Charlotte Department of Transportation

Memorandum

Subject: Rezoning Petition 08-158: Located on the northwest corner of South Mint Street and West Park Avenue
(revised August 14, 2009)

CITY OF CHARLOTTE, MECKLENBURG COUNTY, NORTH CAROLINA
FOR
CONDITIONAL ZONING PLAN
FOR
GREATER GALILEE BAPTIST CHURCH
501 W. PARK AVENUE
AMENDED PETITION #2008-158

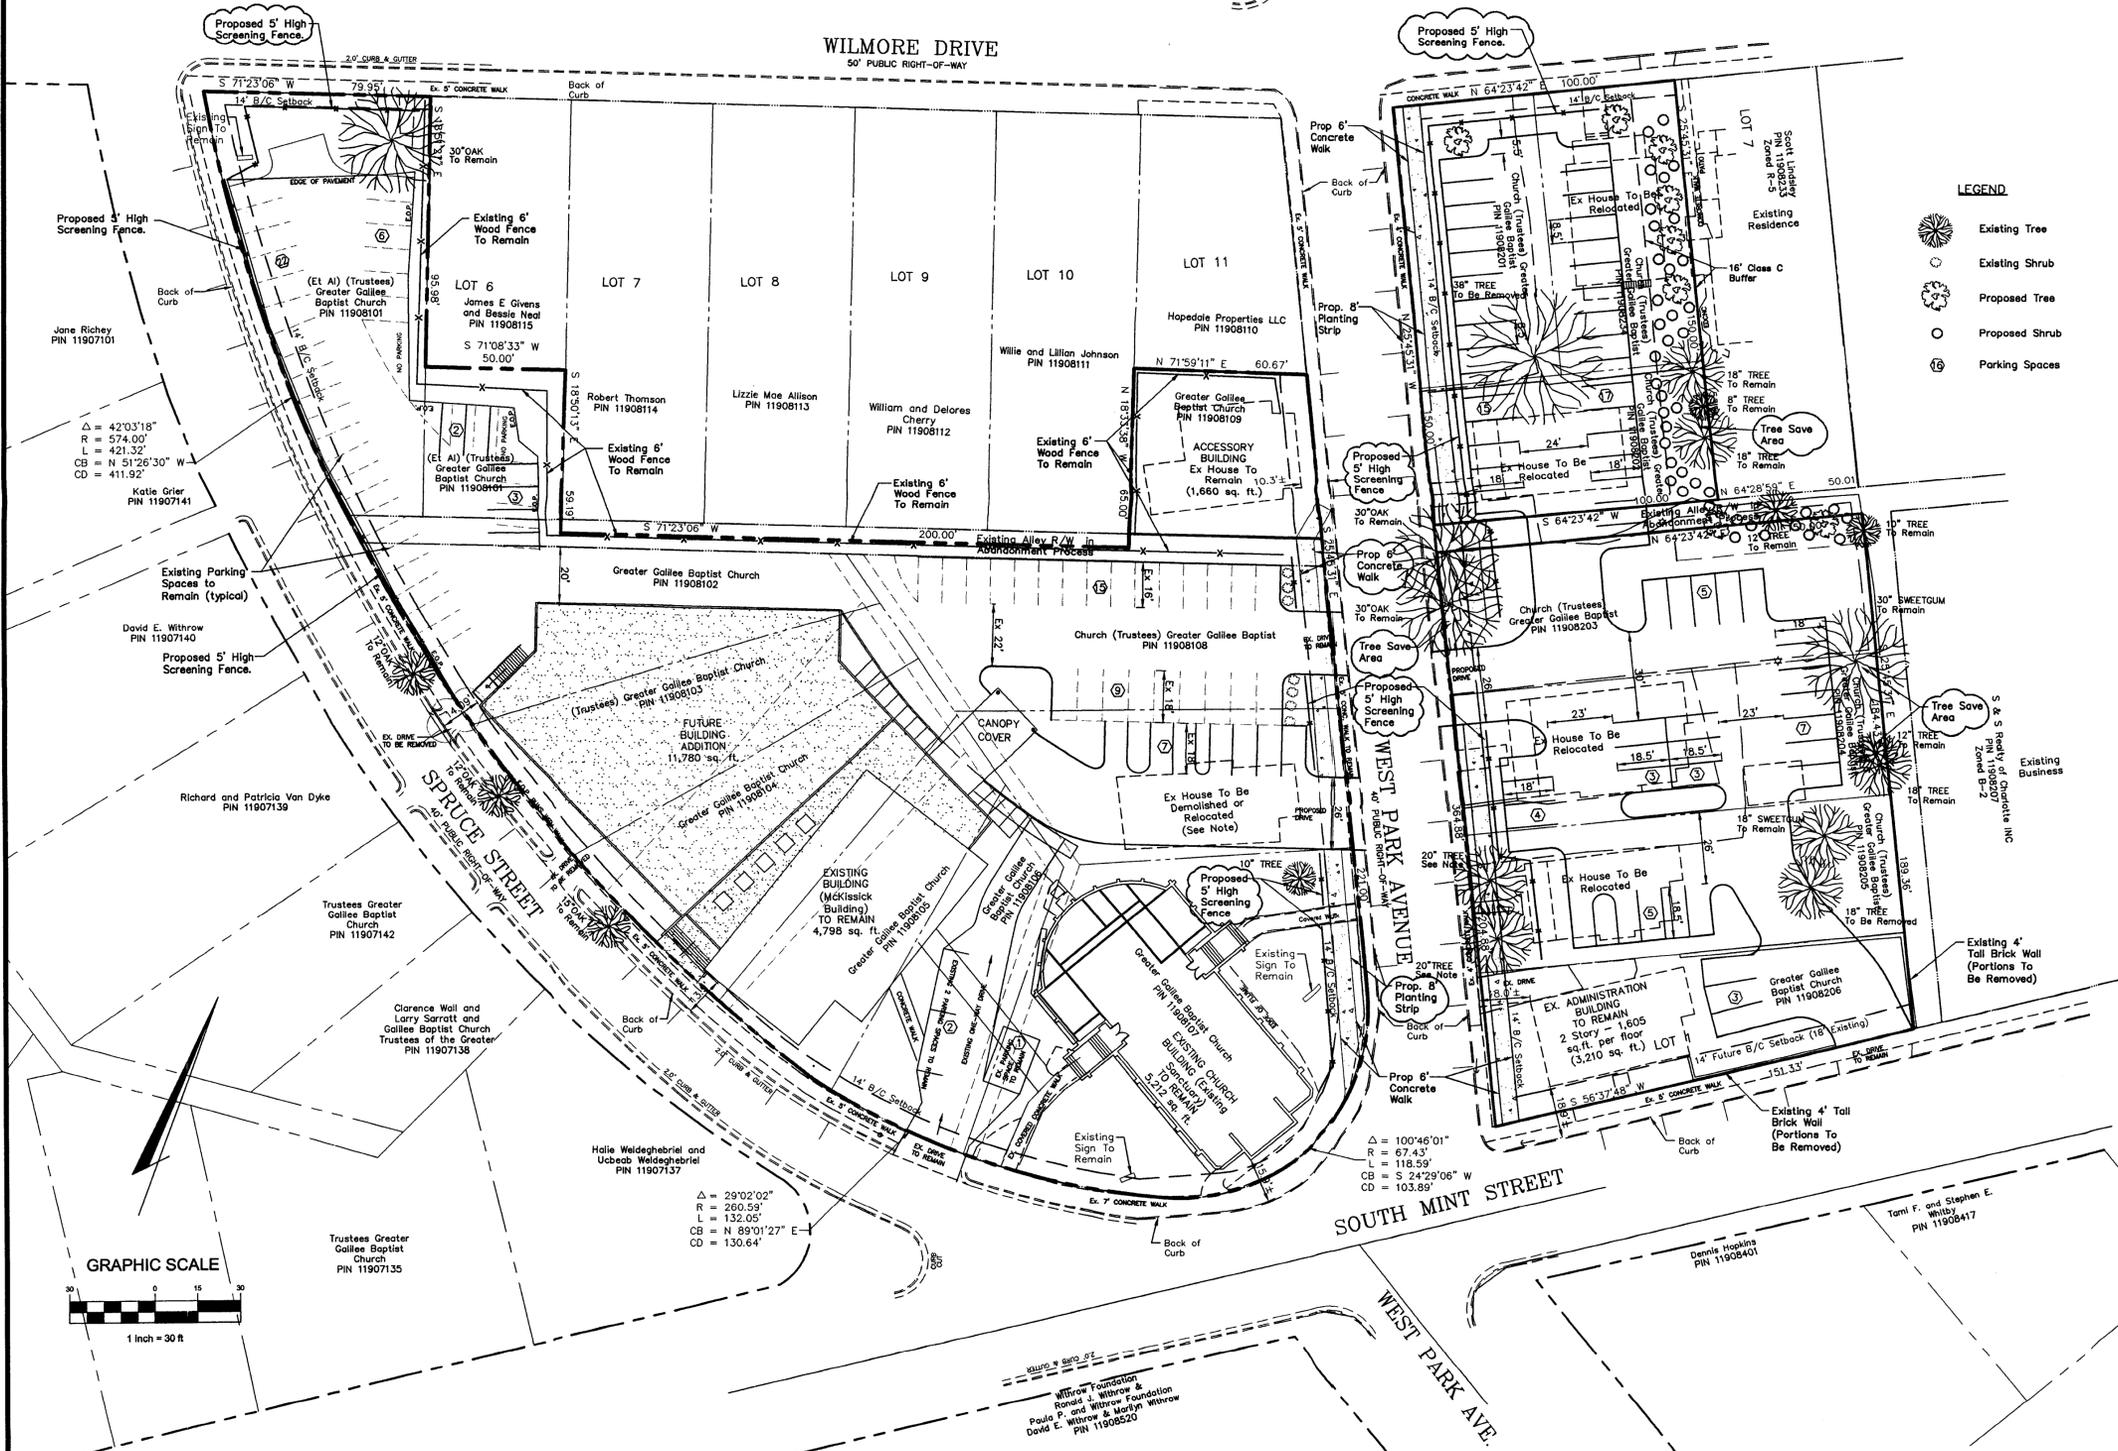
1. Parking calculations need to be included on the site plan to ensure sufficient site parking is available. Charlotte's zoning code requires one parking space for every four seats (i.e. 188 spaces required for this site). Parking calculations need to include all on-site/off-site and on-street parking associated with parking the 750 seating capacity. These parking spaces need to be shown on the site plan. (*Previous review comment*)

2. We recommend an 8' planting strips and 6' sidewalks along both sides of West Park Avenue (as currently shown on the east side of West Park Avenue). A new 6' sidewalk should also be constructed on the west side of West Park Avenue and transition into the existing 7' sidewalk at South Mint Street, in front of the church sanctuary. The proposed new sidewalk on the east side of West Park Avenue near the existing Administration Building many needs to be relocated to pass around all large existing street trees so that they are not damage during new sidewalk construction.

3. A parking turn-out area needs to be constructed at the end of an existing parking lot located in the southeast quadrant of Spruce Street and Wilmore Drive so that vehicles at the end of this parking lot can back into this space to exit the site.

4. An existing 4' tall brick wall along South Mint Street needs to be lowered or removed to provide adequate intersection site distance at South Mint Street and West Park Avenue/Cliffwood Place (southbound looking east).

5. Adequate sight triangles must be reserved at the existing/proposed street entrance(s). Two 35' x 35' and two 10' x 70' sight triangles are required for the entrance(s) to meet current

requirements. All proposed trees, berms, walls, fences, and/or identification signs must not interfere with sight distance at the entrance(s). Such items should be identified on the site plan.
